Our reference: ECM: 9342456
Contact: Kate Smith
Telephone: 02 4732 7705

4 November 2020

Response to Address Amendment Report (AR) and Response to Submissions Report (RtS) - (SSI-9364) for the M12 Motorway

Figure 6-35 Luddenham Road Alignment (Penrith LEP 843) (Item 3) in relation to the amended project

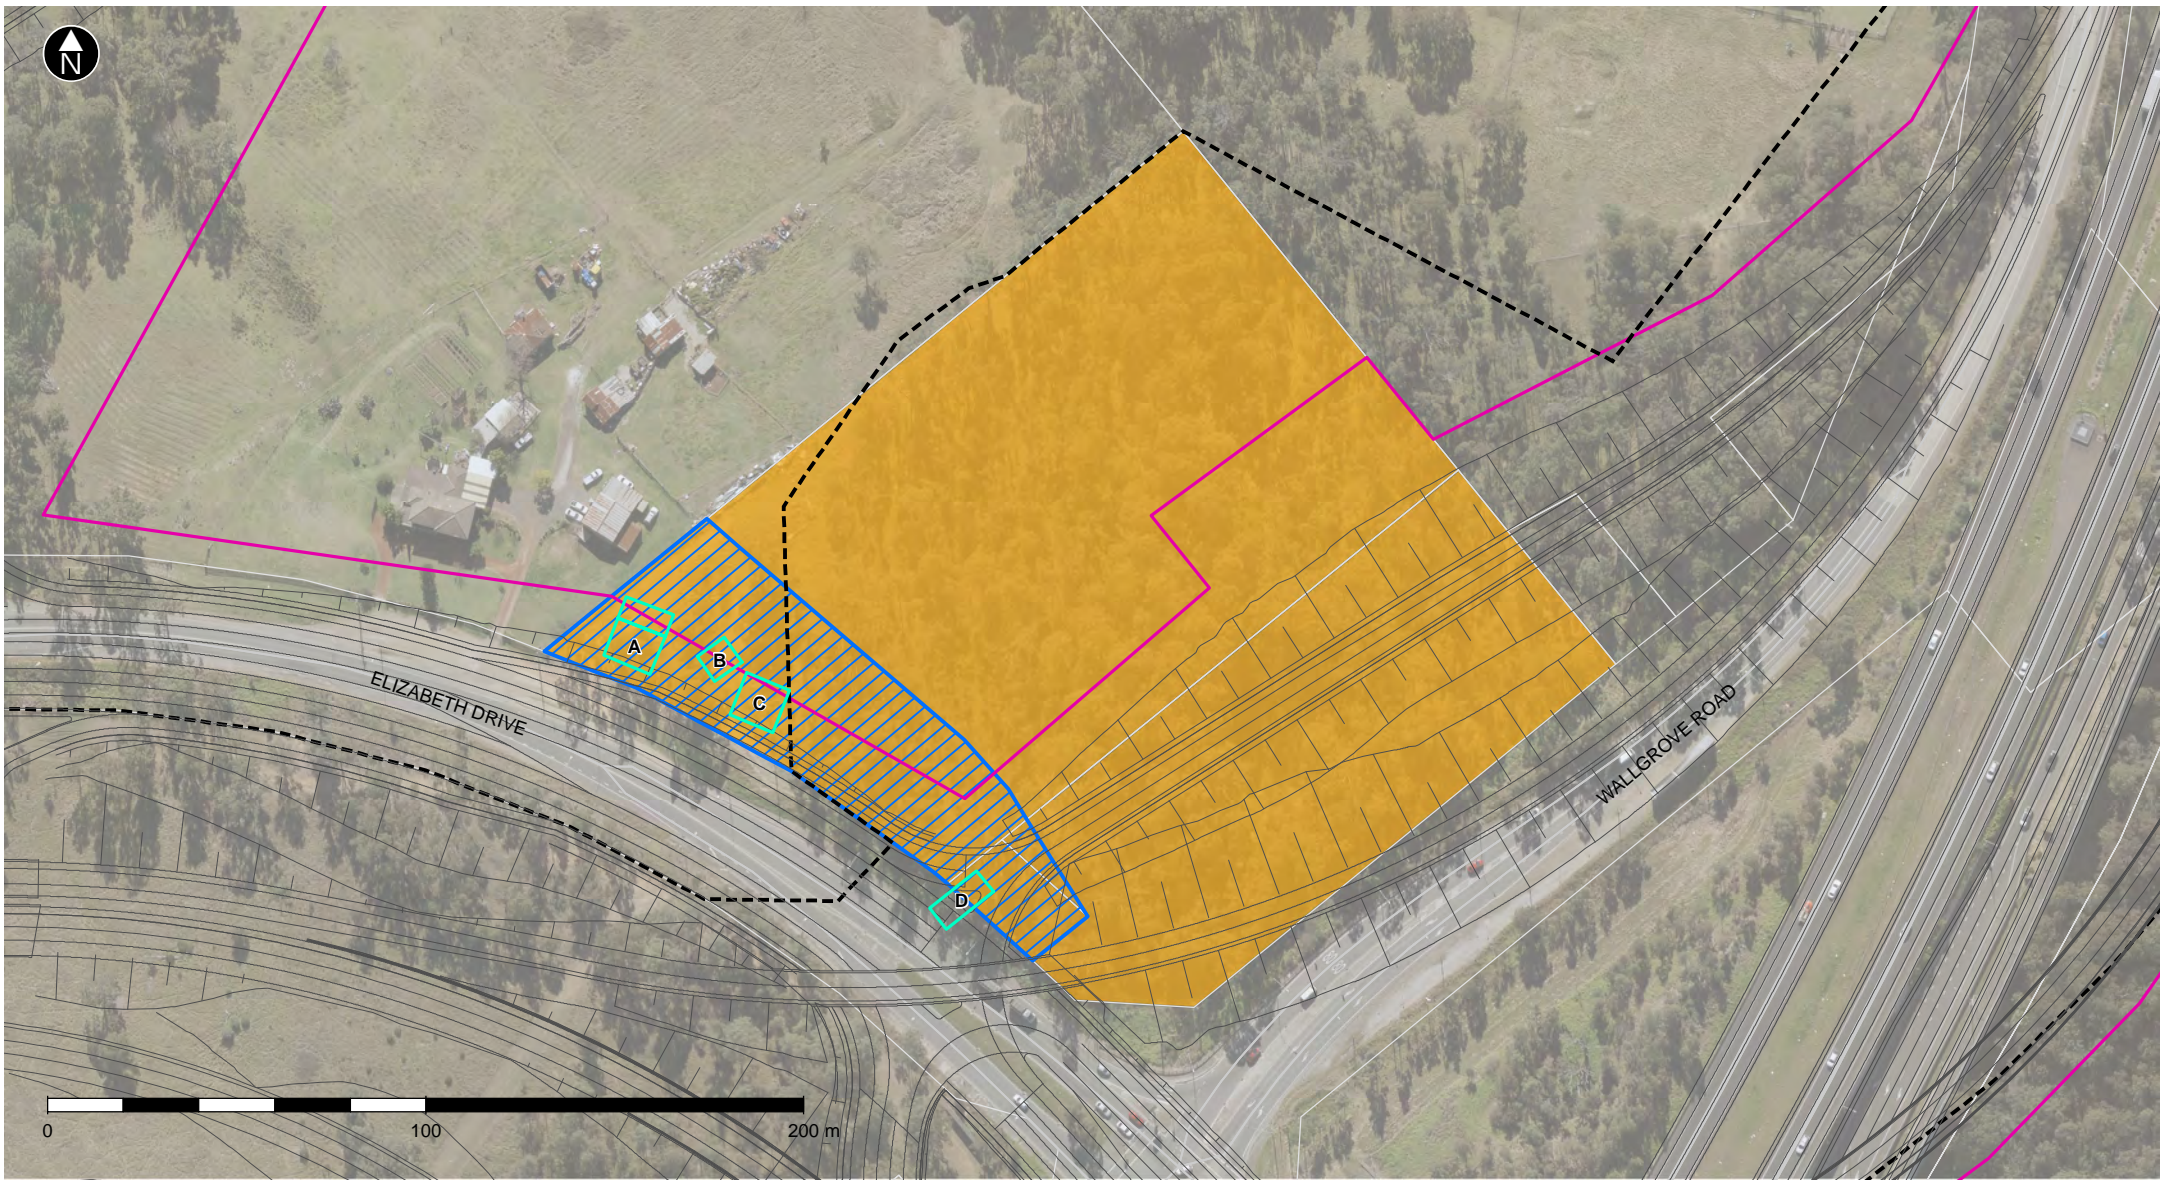
- 3) Prior to the completion of works/Occupation Certificate, the interpretation plan for the McGarvie Smith Farm is to be installed on site.
- The physical description of the heritage item "Luddenham Road" as per the inventory sheet states; The roadway itself is an asphalted two-lane road with grassed verges and some areas with remnant stands of trees. Some sections of the road retain stretches of old timber post and rail fencing that provides evidence of the use of the local area for grazing purposes over a long period of time. I also note that both aesthetic and historical criteria for listing also refer to the post and rail fence and pastoral landscape. Therefore, as previously requested the following is still pertinent; Luddenham Road is also still listed as containing heritage significance and while the reports note impact is minimal it is thought that this might not be the case in respect to road alignment, rural setting, landscaping and fencing. Further discussion should be sought through the amended impact assessment as outlined above.
